Charlotte Department of Transportation

Memorandum

Subject: Rezoning Petition 08-147: located on the north side of Brookshire Boulevard between Oakdale Road and Caldwell Williams Road

1 SITE LAYOUT & PAVING PLAN
C-1
Scale: 1" = 60'

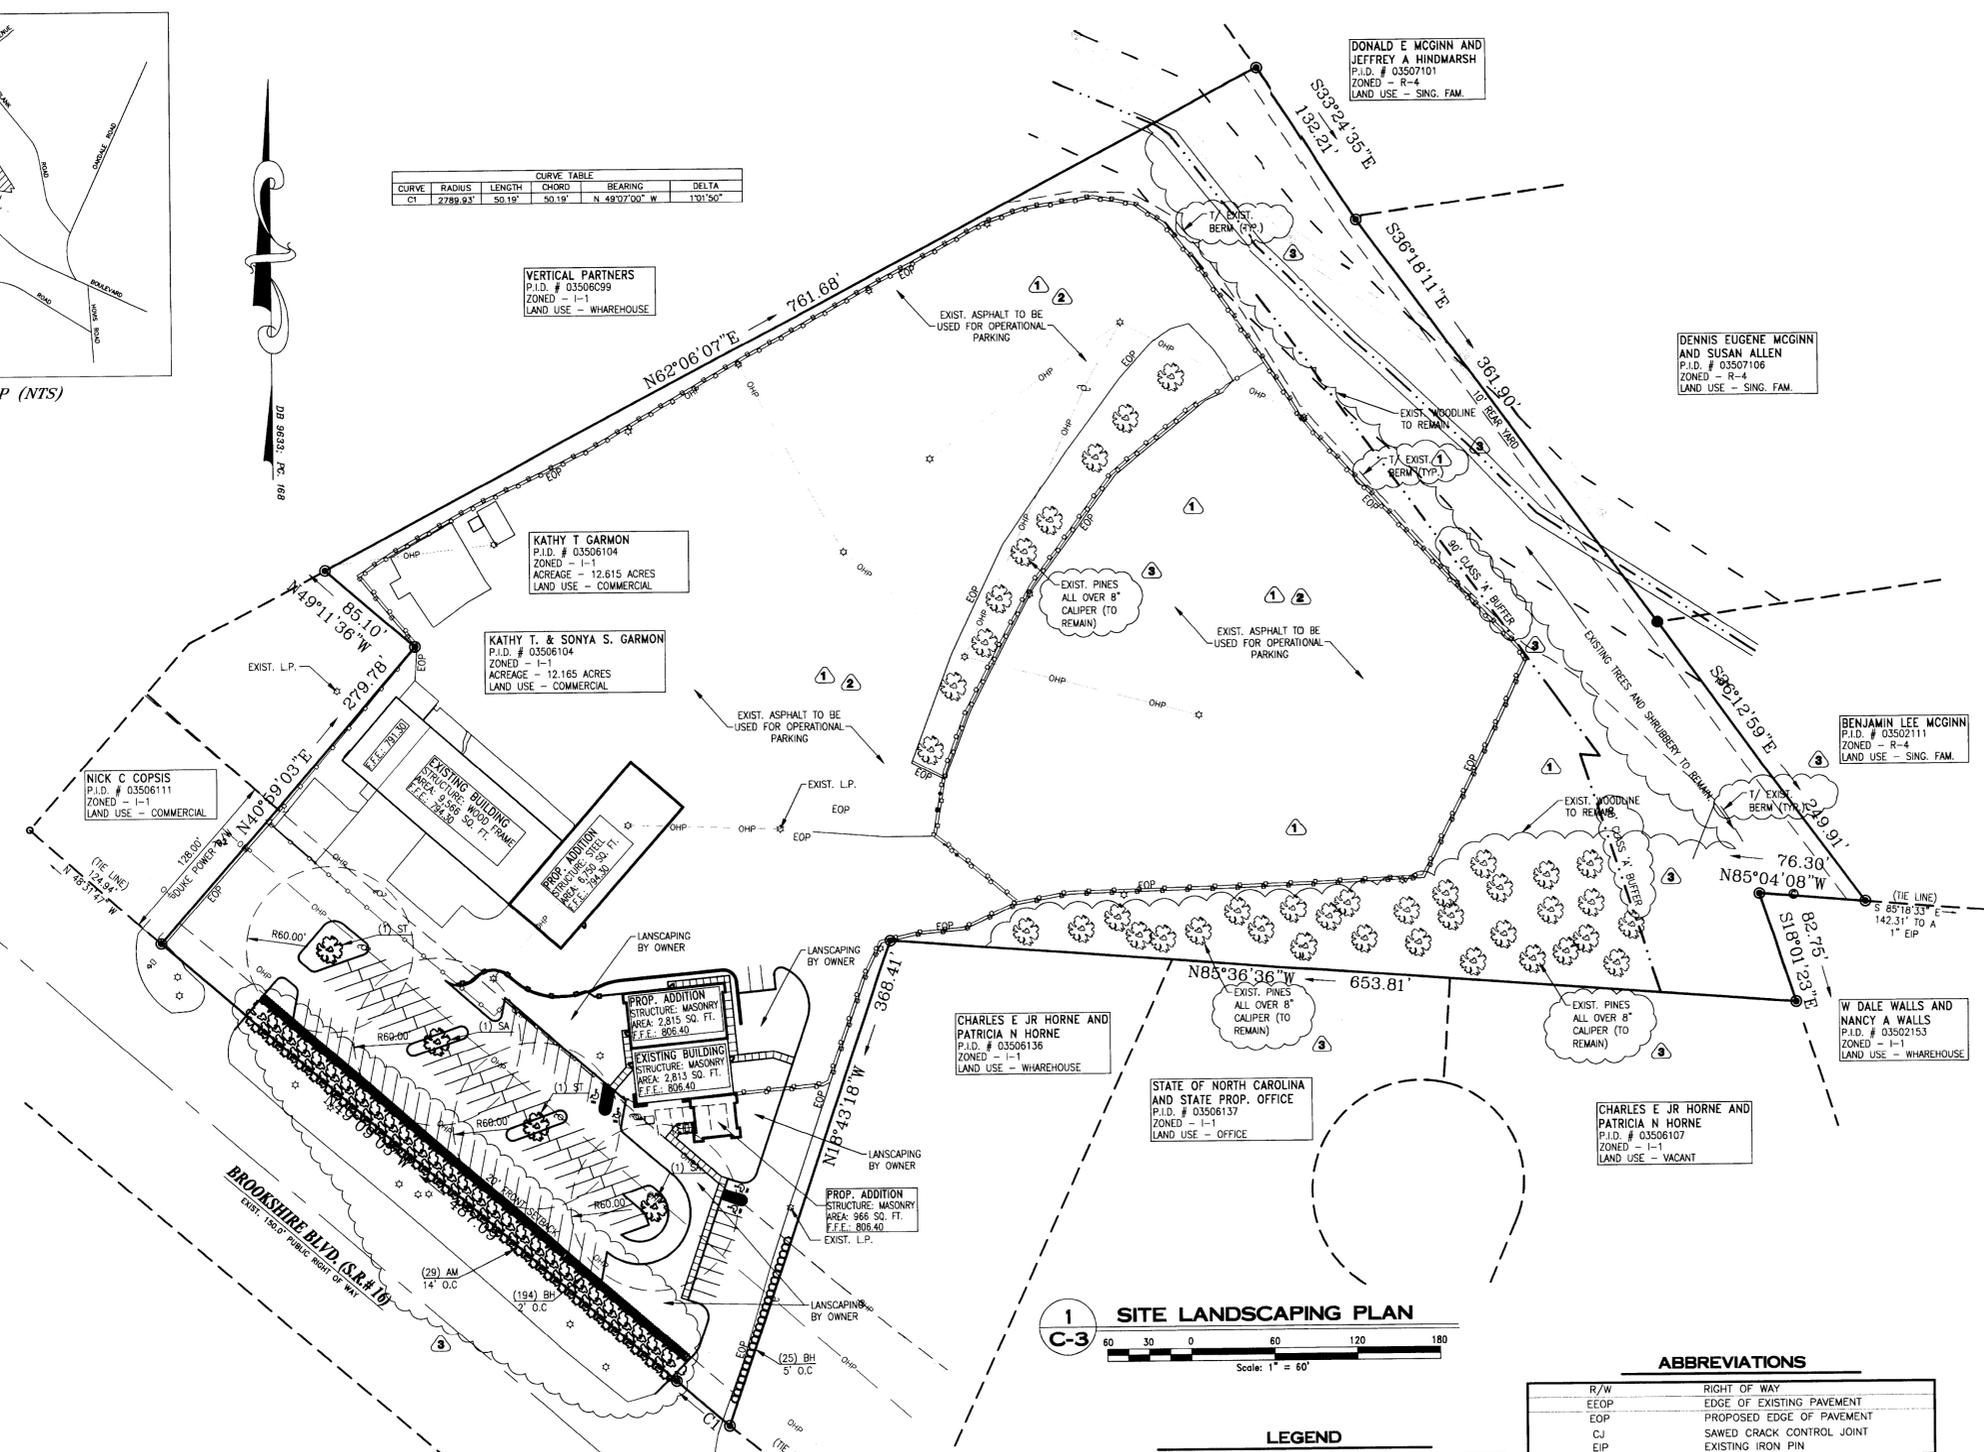
1. Following the design guidance for a Parkway (Urban Street Design Guidelines), the developer needs to construct a 10-foot multi-use path 25 feet from the edge of the outside travel lane along Brookshire Boulevard (NC 16).
2. To facilitate cross-access and reduce unnecessary use of Brookshire Boulevard, a driveway connection needs to be made to the existing stub driveway on DMV Drive.

3. The existing southern drive on Brookshire Boulevard does not meet minimum standards for offset from side property line and angle. It needs to be realigned to perpendicularly connect with Brookshire Boulevard.

This section of Brookshire Boulevard is a Class II-Limited Access thoroughfare requiring a minimum of 200 feet of right-of-way. The developer/petitioner should convey right-of-way in fee-simple title to meet this requirement, measuring 100 feet from the centerline of the roadway.

Adequate sight triangles must be reserved at the existing/proposed street entrance(s). Two 35' x 35' and two 10' x 70' sight triangles are required for the entrance(s) to meet requirements. All proposed trees, berms, walls, fences, and/or identification signs must not interfere with sight distance at the entrance(s). Such items should be identified on the site plan.

- Meet applicable standards in the Charlotte Land Development Standards Manual (latest revision).
- Dimension width of the existing and proposed driveways.
- New/reconstructed driveways must be drop curb Type II-Modified driveways.
- Indicate the locations and widths of all adjacent and opposing driveways.
- Indicate typical parking module dimensions.

Include a parking summary with figures for the numbers of parking spaces required and provided.

Directional wheelchair ramps (two per corner) should be provided at all intersections of public and private streets.
